# COUNTY COUNCIL'S RESPONSE TO CONSULTATION ON THE FOLLOWING DEVELOPMENT PROPOSAL

**Application No:** 18/01309/RM

**Proposal:** Reserved matters application for 14/02156/OUT - appearance, landscaping and layout (including the layout of the internal access roads, footpaths and cycleways) for 58 dwellings.

**Location:** Land South Of Cotefield, Business Park Phase 2 Adj To Blossom Field Road, Bodicote.

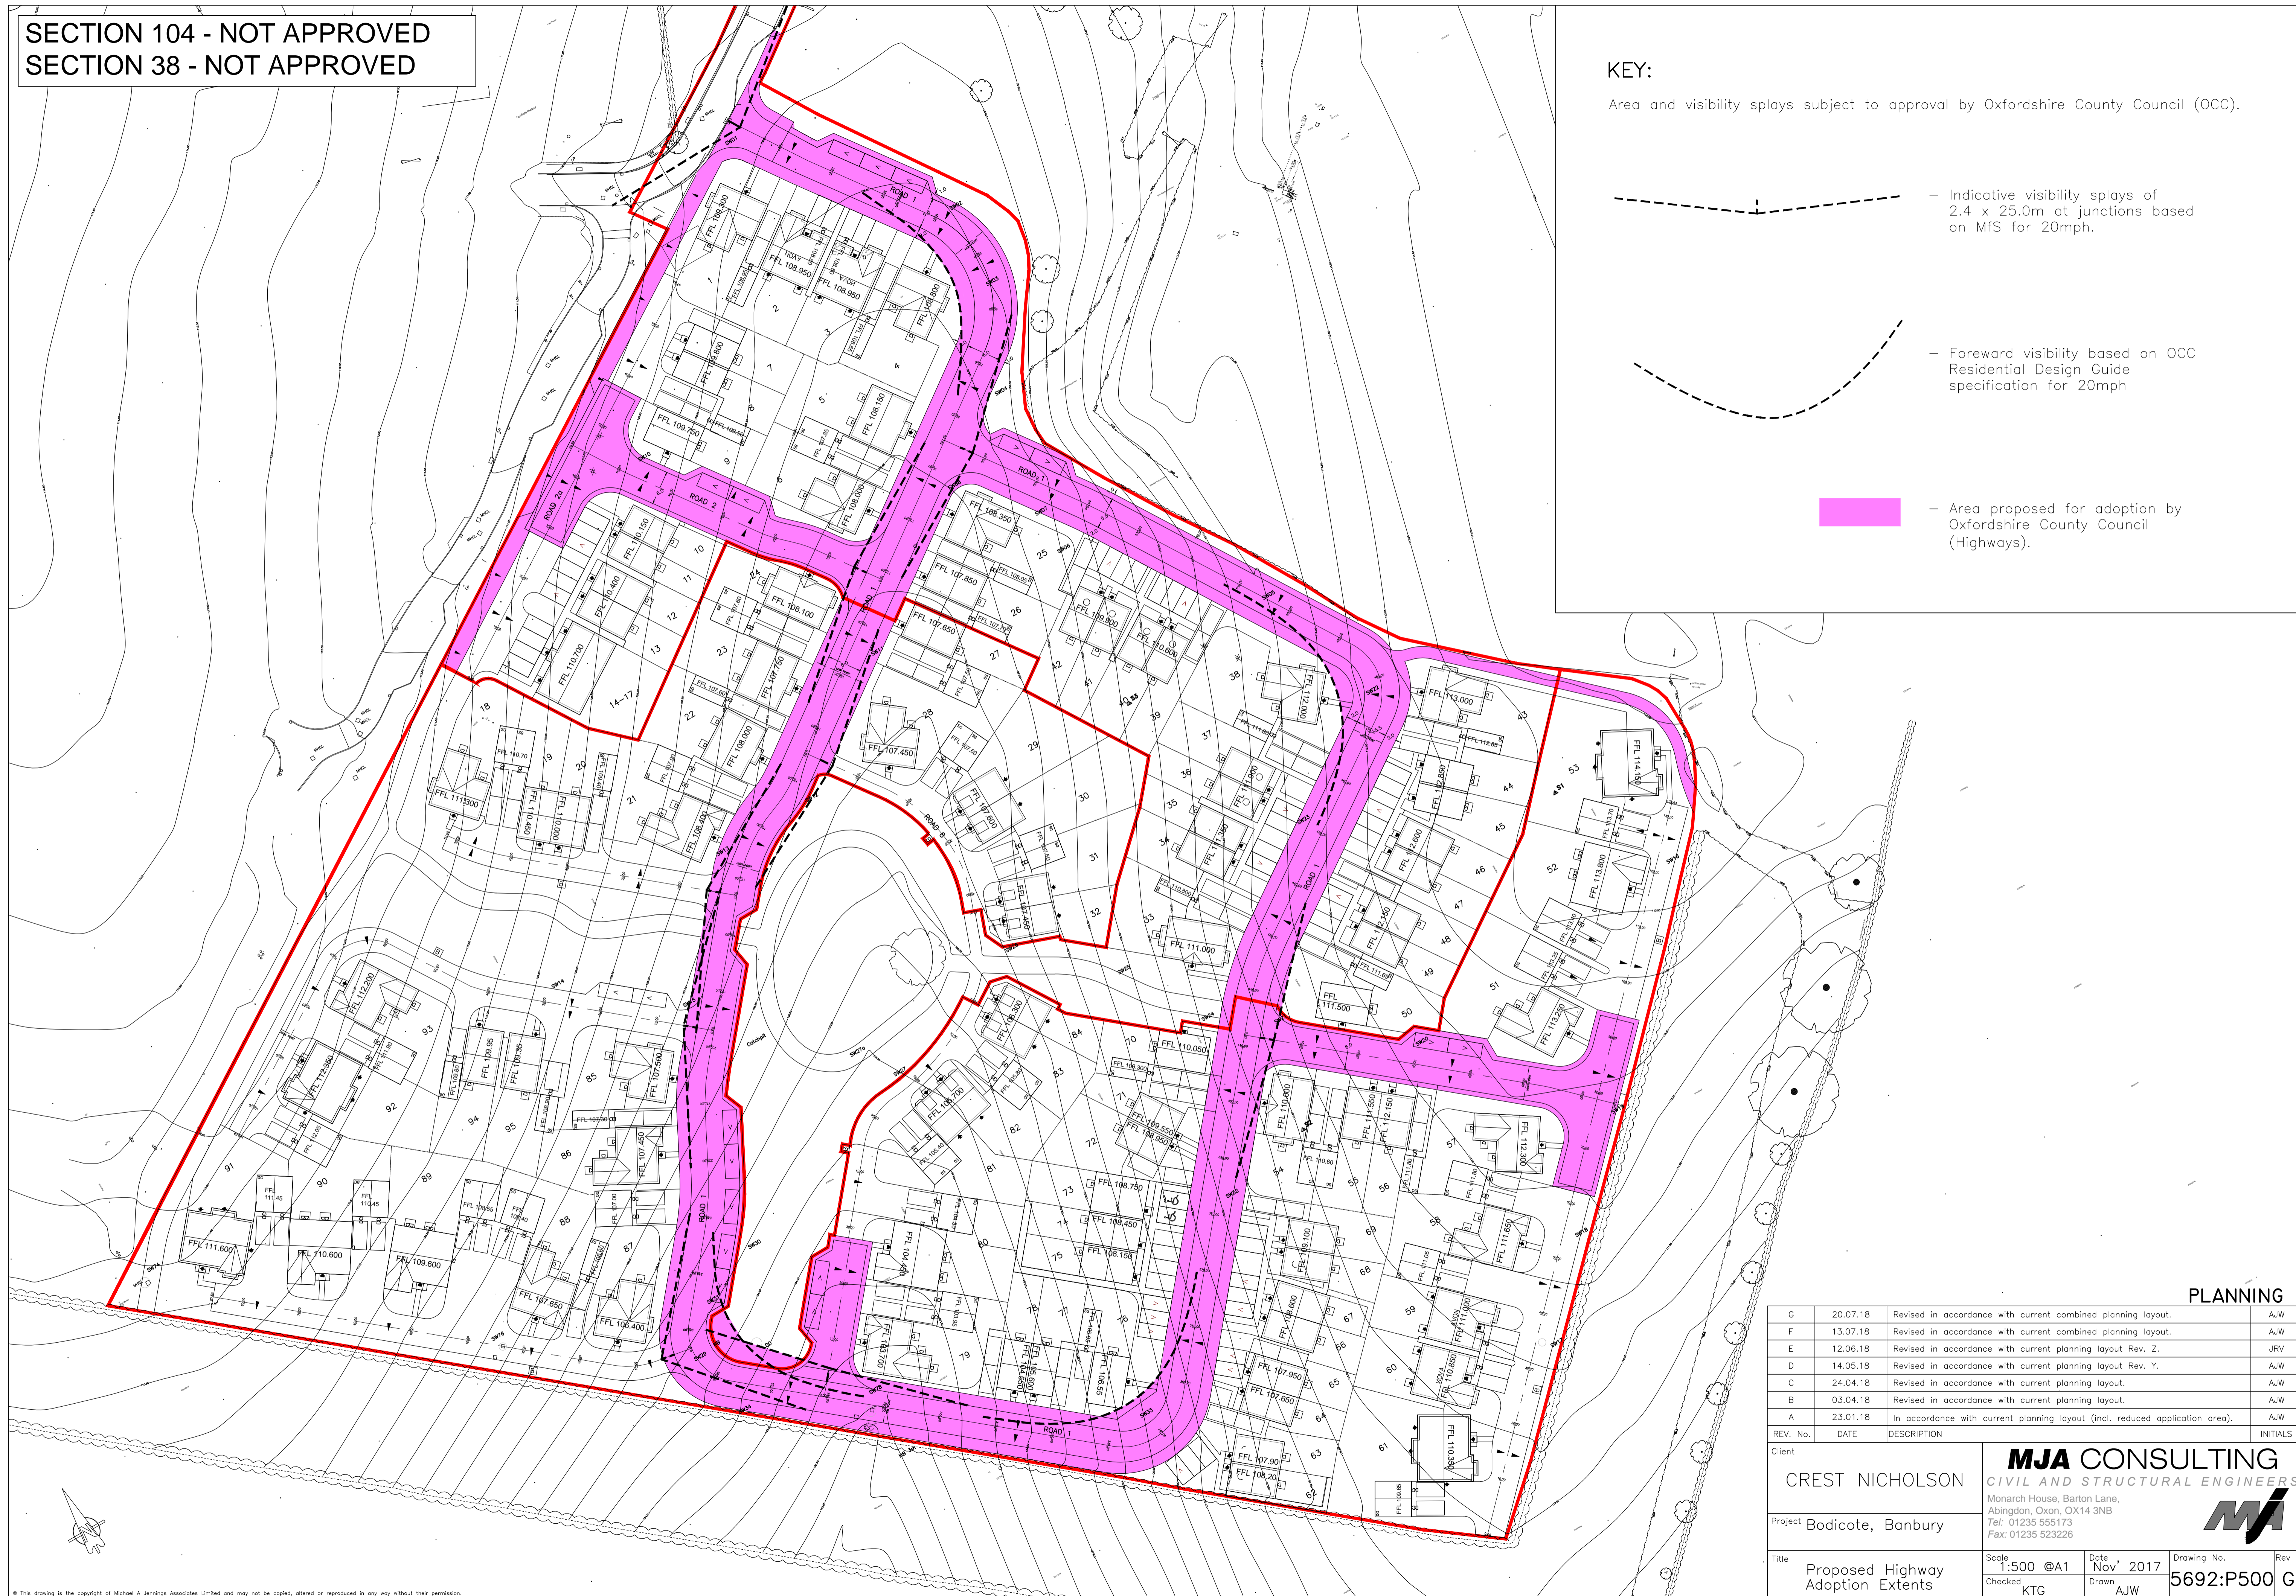
**Drawing No. 5692:P500G.** Forward visibility opposite plot No.87 around bend goes through a visitor parking bay. This is not acceptable and the parking bay should be removed from the splay. It is noted that gaps are shown between this provision of visitor parking bays. Capacity would be better used if bays are butted up to each other as per the standard practice. **Reason for objection.**

**Drawing No. 5692:P500G.** The County would not adopt the area in front of Plot Nos.79 and 80. **Reason for objection.**

**Drawing No. 5692:P500G.** The footway link to the side of plots 43 and 53 stops at the red line boundary and it is not clear whether it ties in with any existing provision. The County would not adopt this link if it does not link to highway. **Reason for objection.**

**Drawing No. 5692:P500G.** Parking outside plot No.62 is not ideal on the bend. Cars reversing out will have difficulty in peak times. **Reason for objection.**

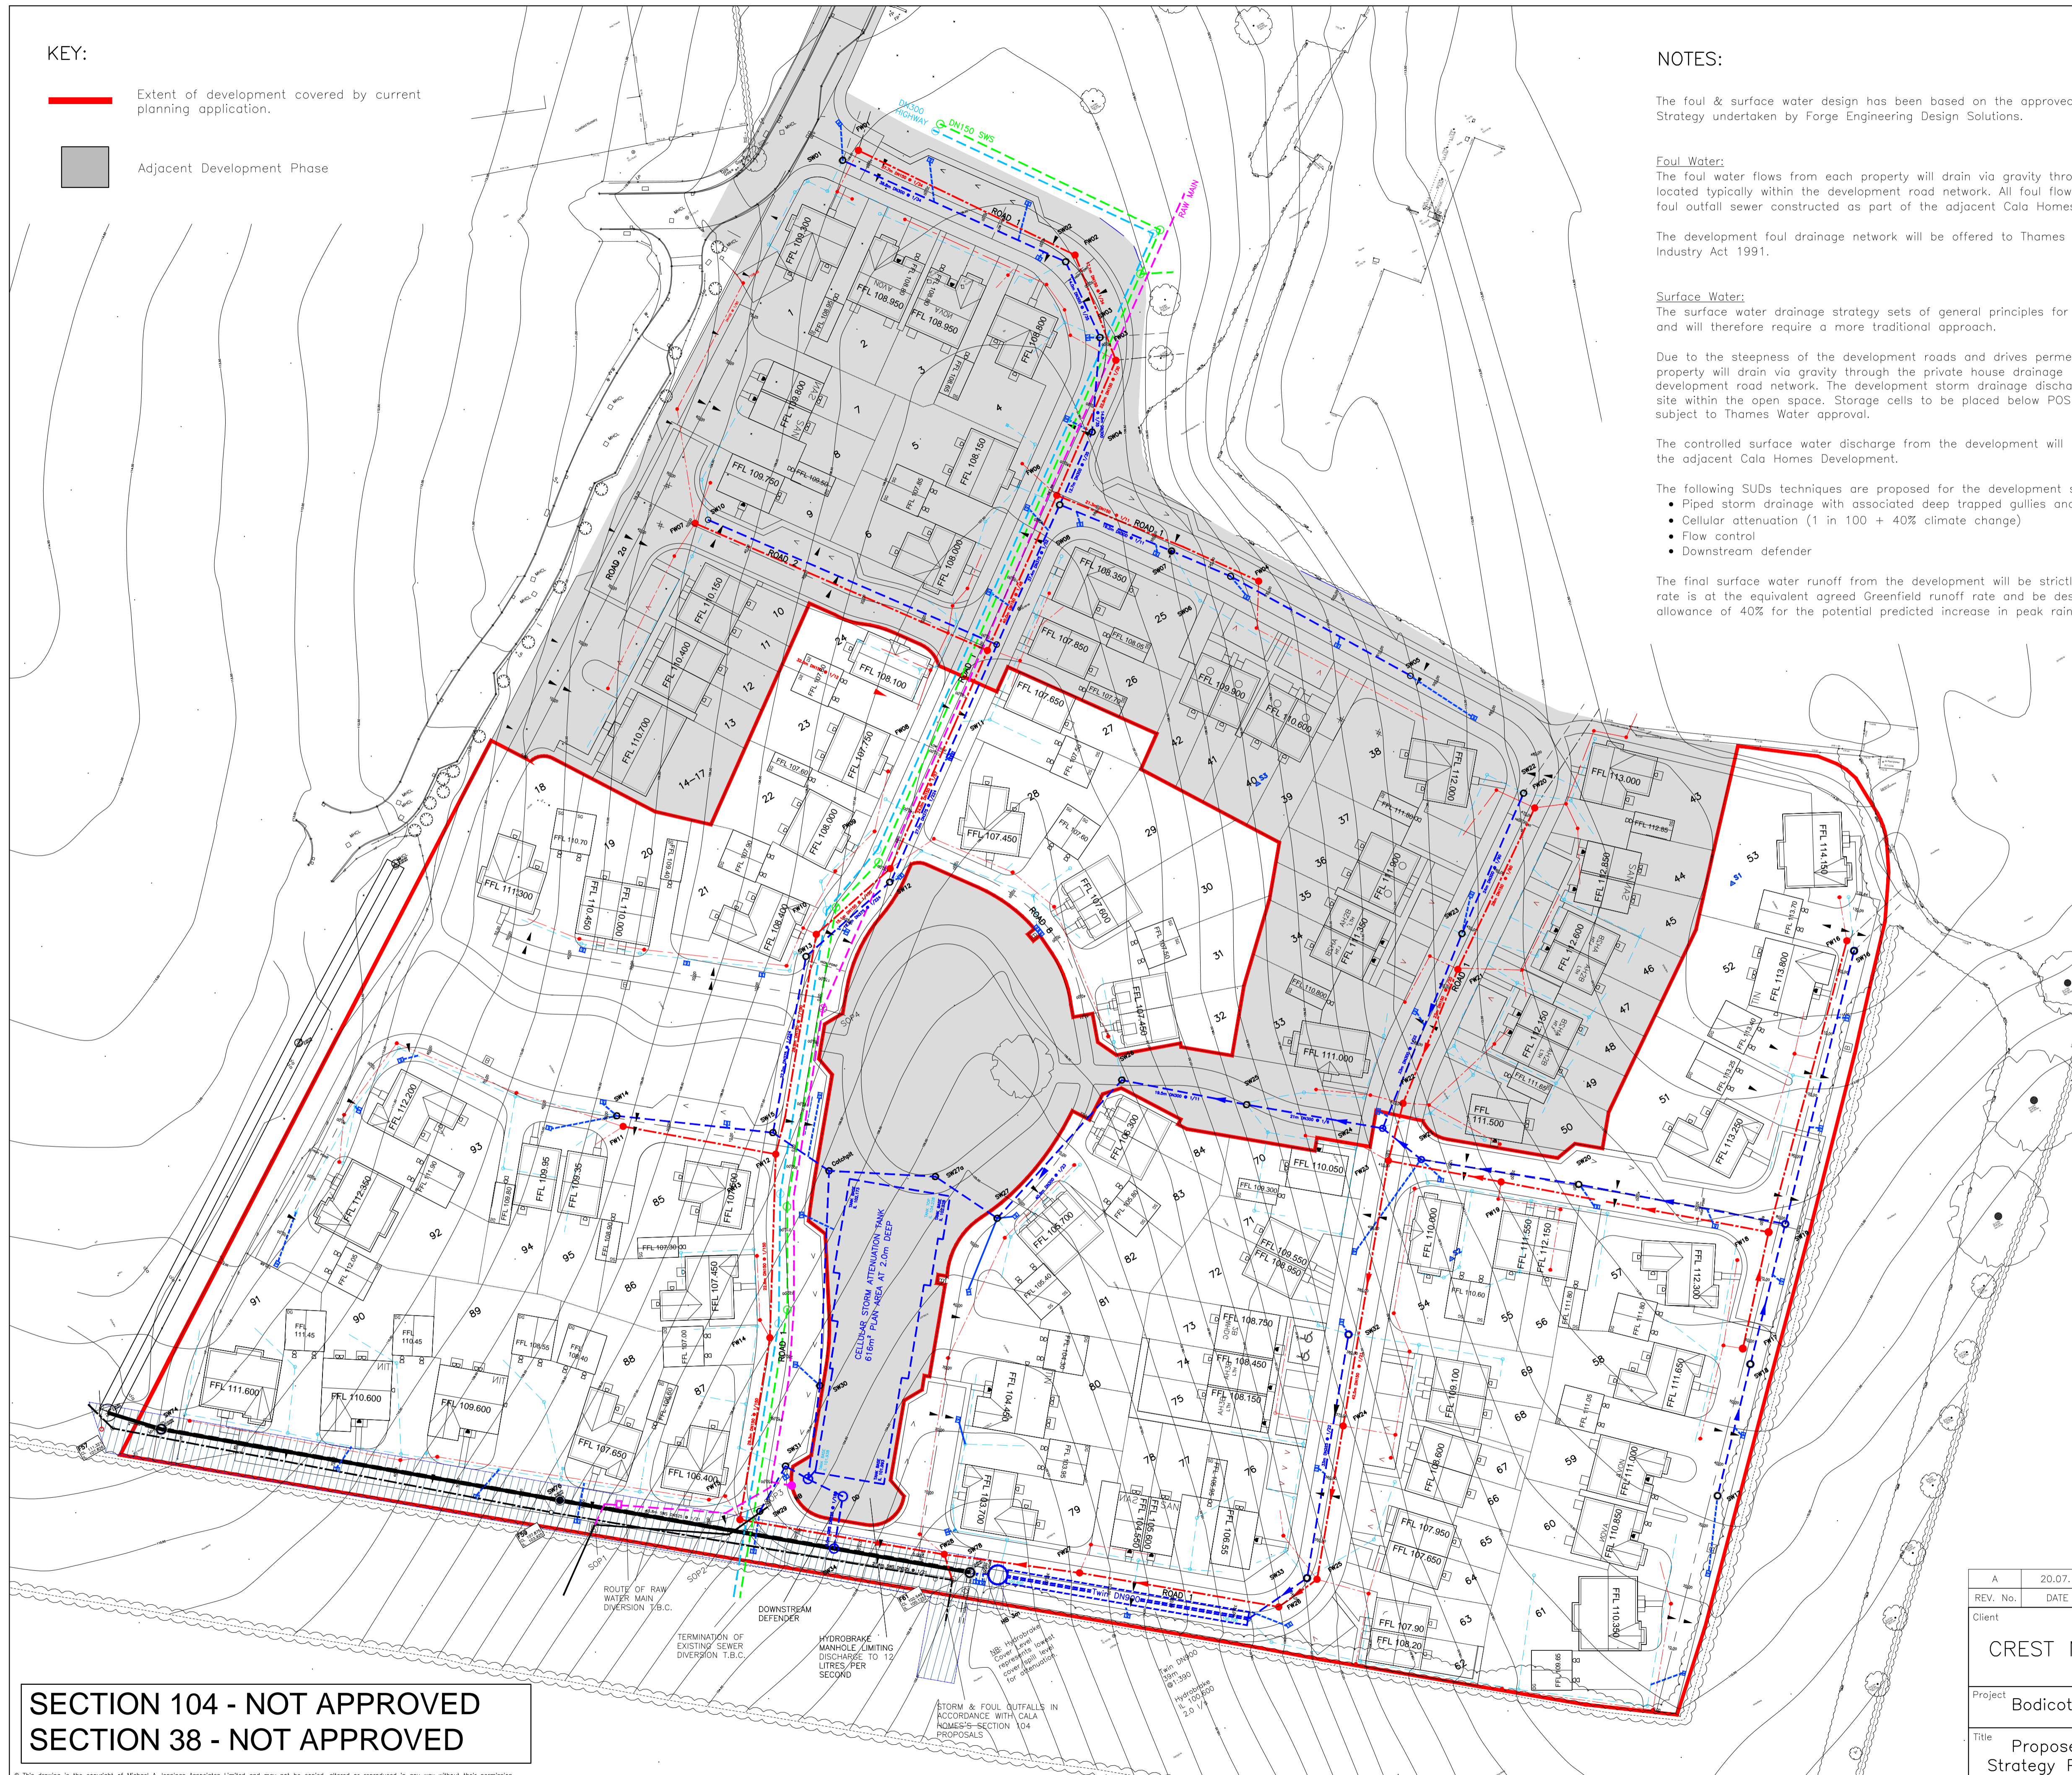
The drainage proposals accompanying this Reserved Matters application (18/01309/REM) highlights the risk of slip planes and springs to occur between limestone and clay layers at the site if infiltration were used due to site gradients. The current application proposes a conventional drainage system and underground attenuation tank to manage surface water.

However, the County considers infiltration may be possible in some areas of the site. It is understood that a neighbouring Cala Homes site does use infiltration techniques where practicable. The County considers some infiltration may be possible on lower areas of the site, and expects that the Applicant seeks the advice of a geotechnical specialist to confirm the assertion that slip planes could develop if infiltration were used on higher areas of the site. Given the proposed absence of the use of any infiltration at the site, the County objects to the application. **Reason for objection.**
